Planning Inspectorate Reference: EN010012
Our Identification Number: 20025459

Planning Act 2008 – Application by NNB Generation Company (SZC) Limited for an Order Granting Development Consent for The Sizewell C Project

Deadline 6 Submission

This document comprises the MMO's comments submitted in response to Deadline 6.

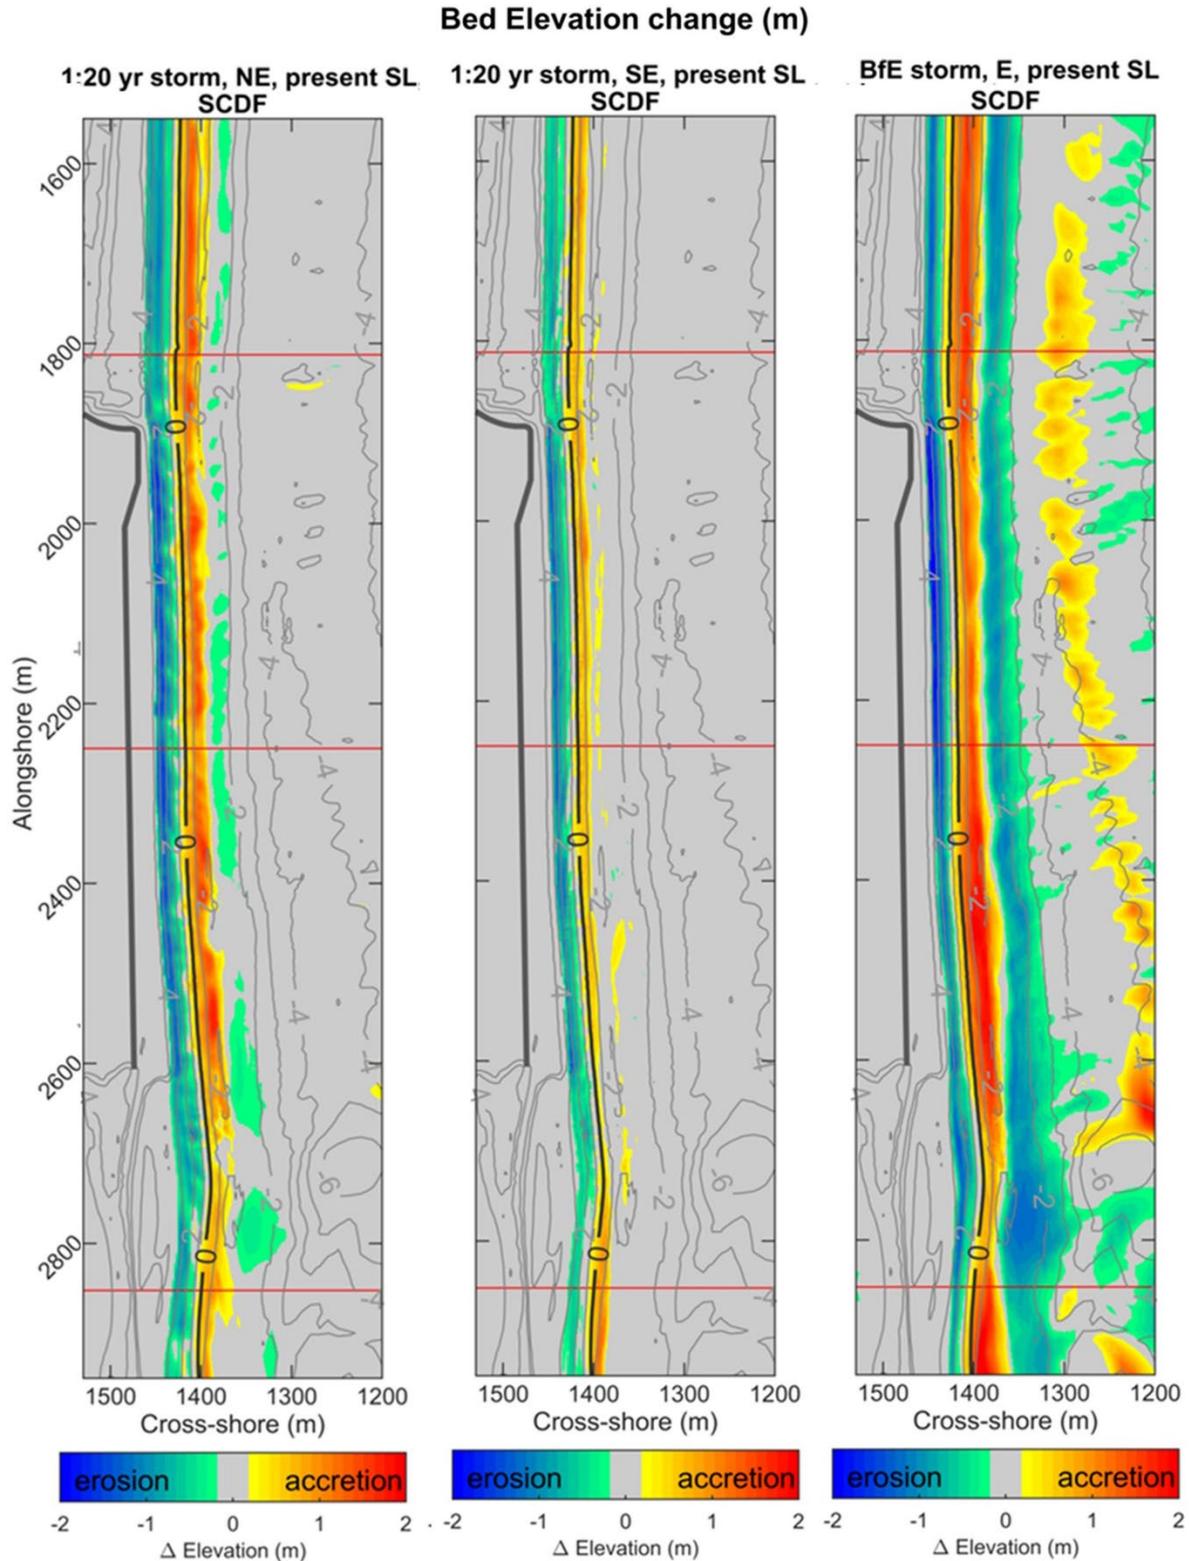
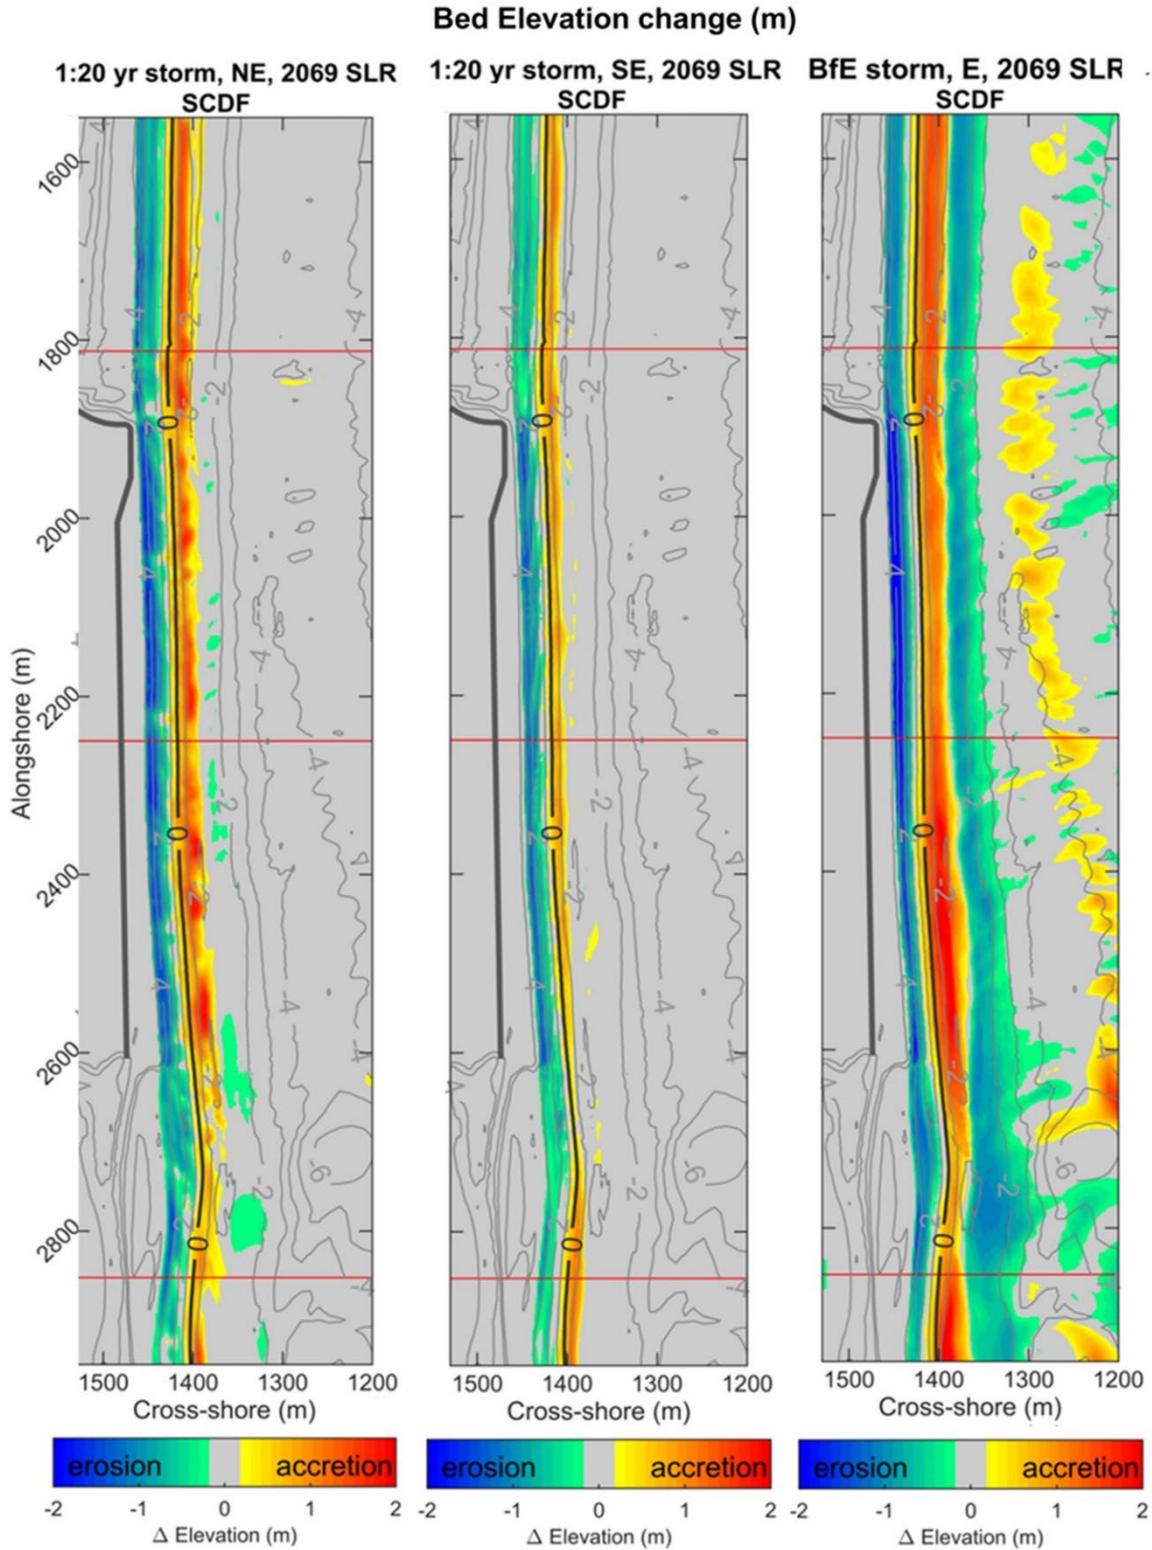
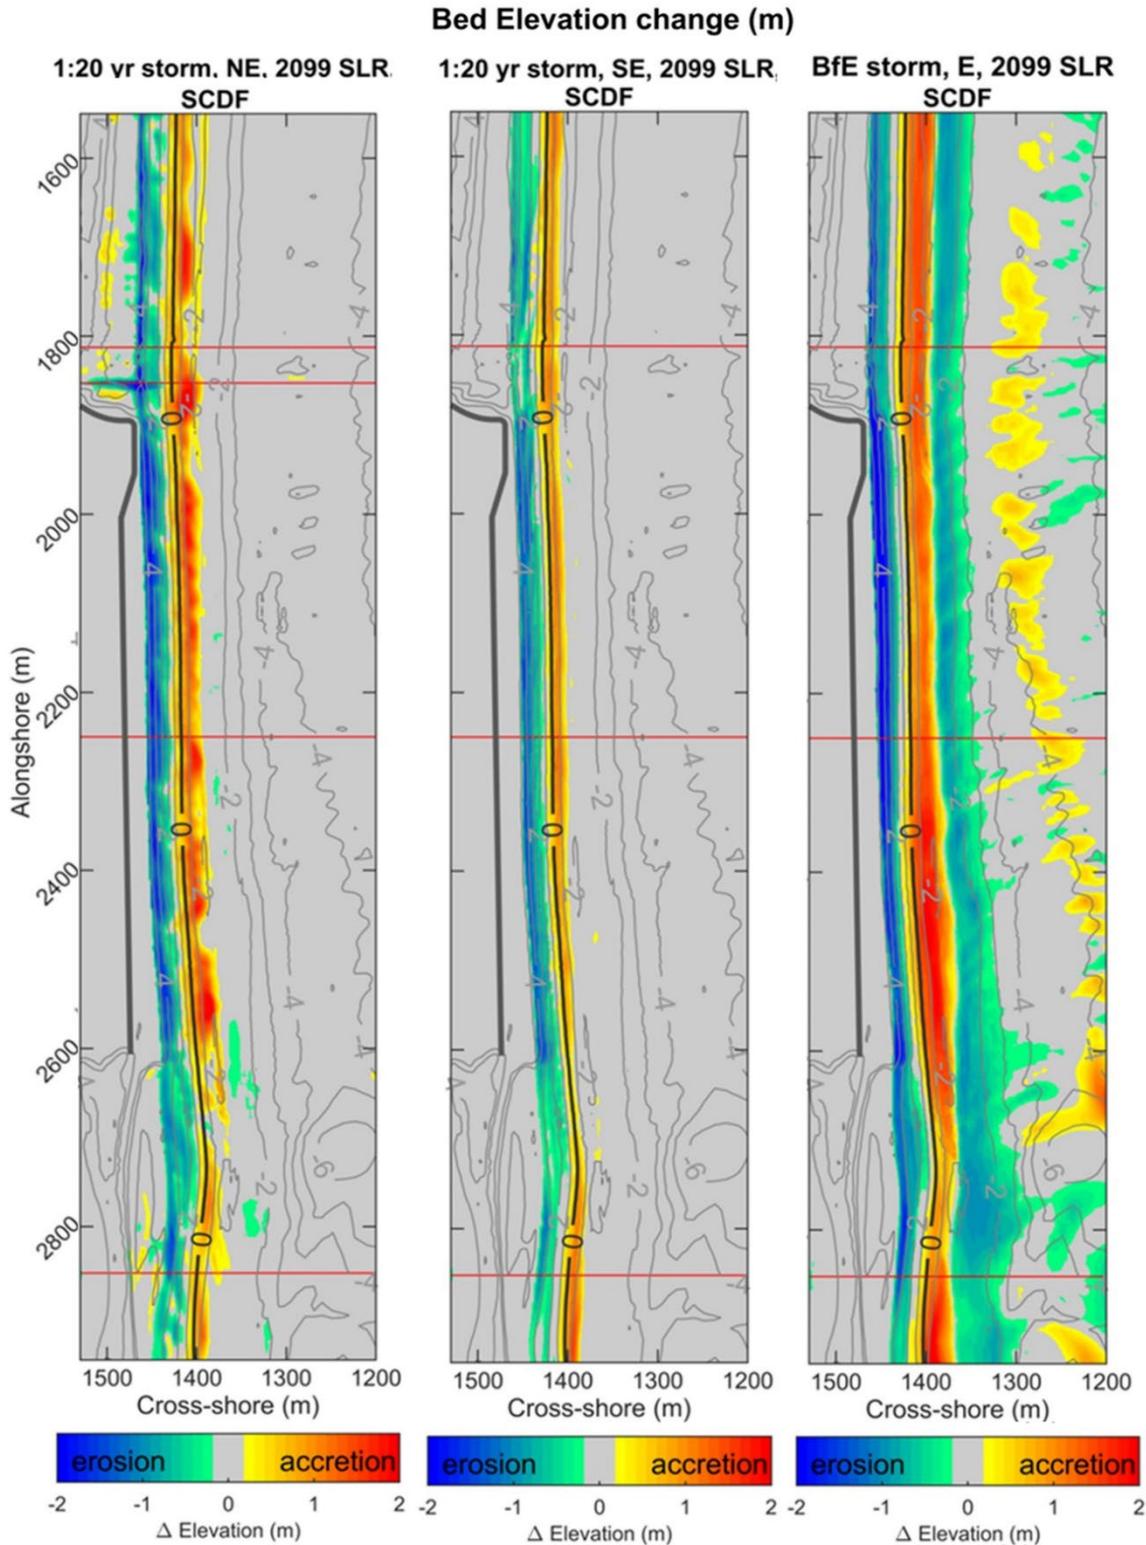
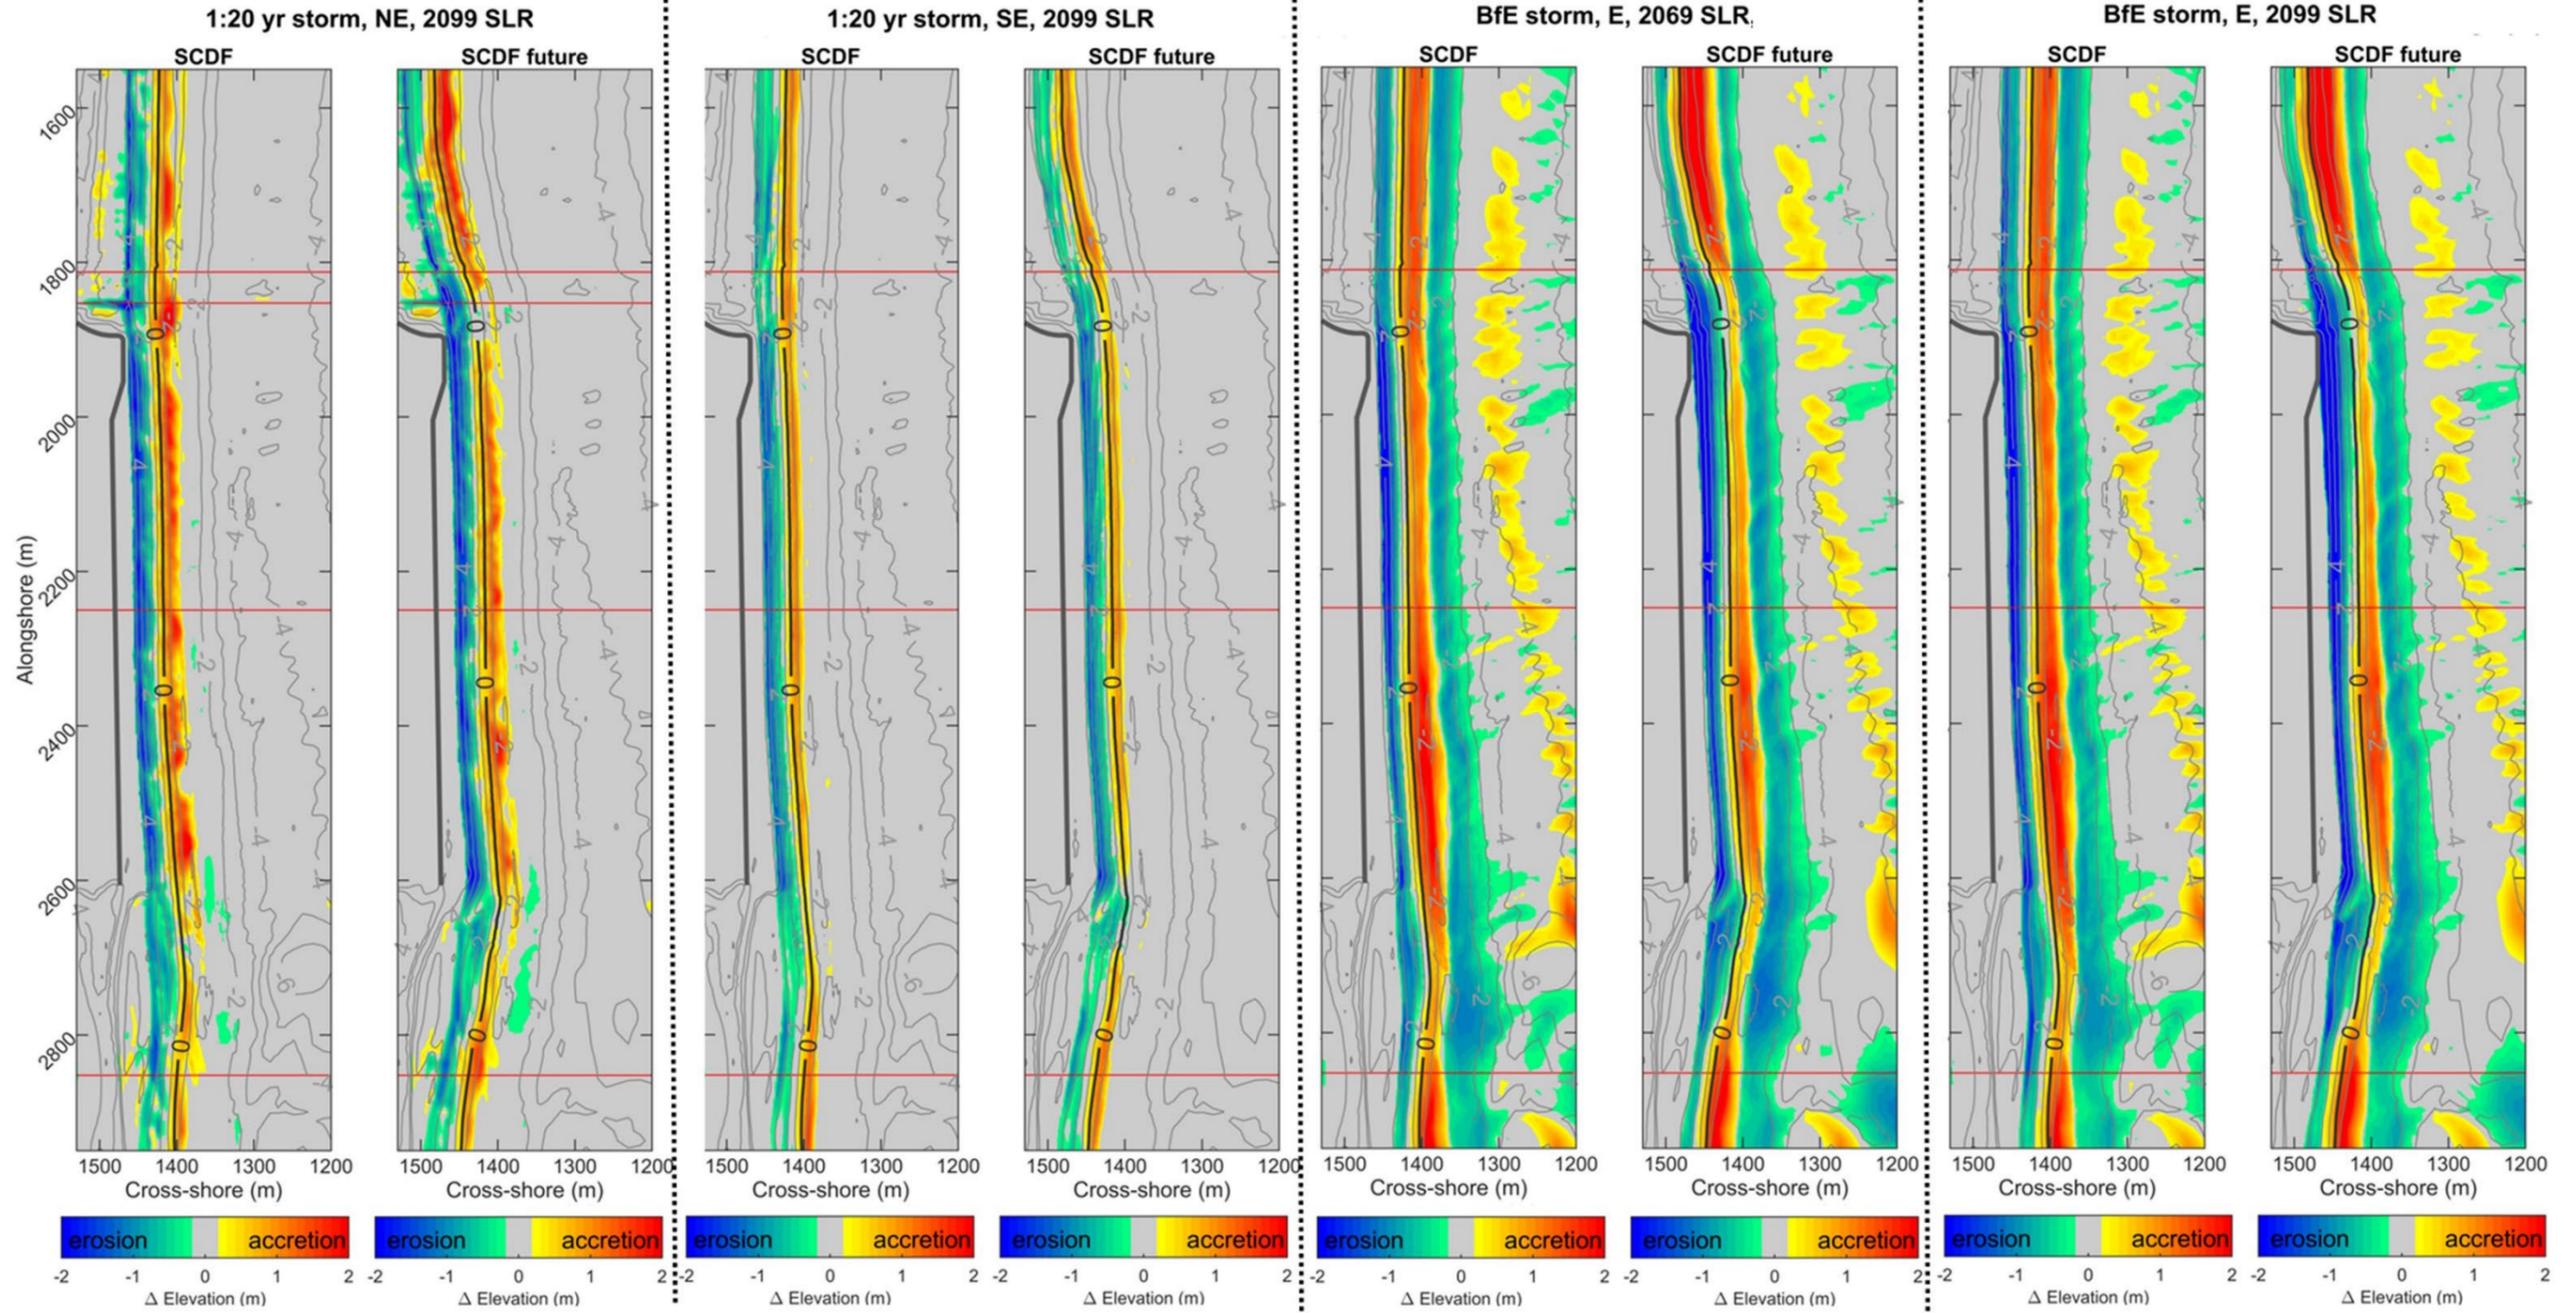
3.1 Comments on Report TR545 - Two dimensional modelling of the Soft Coastal Defence Feature - [REP3-048]

- 3.1.1 The MMO has reviewed the modelling for the SCDF that has been submitted to PINS by the Applicant. We have provided our comments on the one dimensional modelling [REP2-115] within section 5 of our Deadline 5 response. To summarise our comments on this modelling, we raised concerns about the proposal to use much coarser material for the SCDF than the native grain size present within the area as there has been no evidence provided to show that this will not have a negative impact on the neighbouring coastline and nearshore morphology. This is a very significant gap in the evidence in the MMO's view. We also raised concerns about the approach taken in this report to assess the suitability of the crest height for the SCDF. MMO asked for clarity from the Applicant on whether a proper flood risk study has been performed to assess the critical height for the Hard Coastal Defence Feature ("HCDF"), as the SZC facility will be protected against flooding by the HCDF structure, behind the SCDF.

- 3.1.2 Our main concerns after reviewing the two dimensional modelling are very much the same as those we have raised in relation to the one dimensional modelling. See our detailed comments on REP3-048 below.

- 3.1.3 As the project area is quite complex, the MMO recognises that there may not be a model available that is suited to assess the specific coastal geomorphology impacts that could occur in this area from the SCDF. XBeach contains up to date science and knowledge on nearshore wave dynamics and the resulting erosion for sand, and XBeach- G is a recent development that is more suitable for gravel beaches and SCDF structures with uniform coarse material. However, XBeach does not deal well with mixed sediments or spatially varying grain sizes. Therefore, whereas the MMO agree that the modelling is appropriate to assess the stability of the SCDF, the model is unable to reliably model the impact of the SCDF on the wider area, including the beach in front of the SCDF and the coast immediately north and south of it. This would require a model that is better suited to represent the mixed sediment conditions at the site.

- 3.1.4 As a result of the uncertainty concerning impacts on the wider area, the MMO advise that further modelling should be provided. We recommend that as a minimum, the 2D XBeach model is run with a sand fraction with and without the SCDF, to compare the impact on the coastline to the south and north of the SCDF. Ideally this would be done with a model that can deal with spatially varying grain sizes. As the model is unable to use multi grain fractions, the SCDF should be modelled as a hard structure, and the natural beach should be modelled with sand to provide a worst case scenario.

- 3.1.5 In relation to the size of the sediment used for the SCDF, the MMO agree with the Applicant's conclusion that larger particles for the SCDF will increase the stability of the SCDF and this is beneficial from a site protection point of view. However, coarser material will be less mobile. This will increase the risk of scour
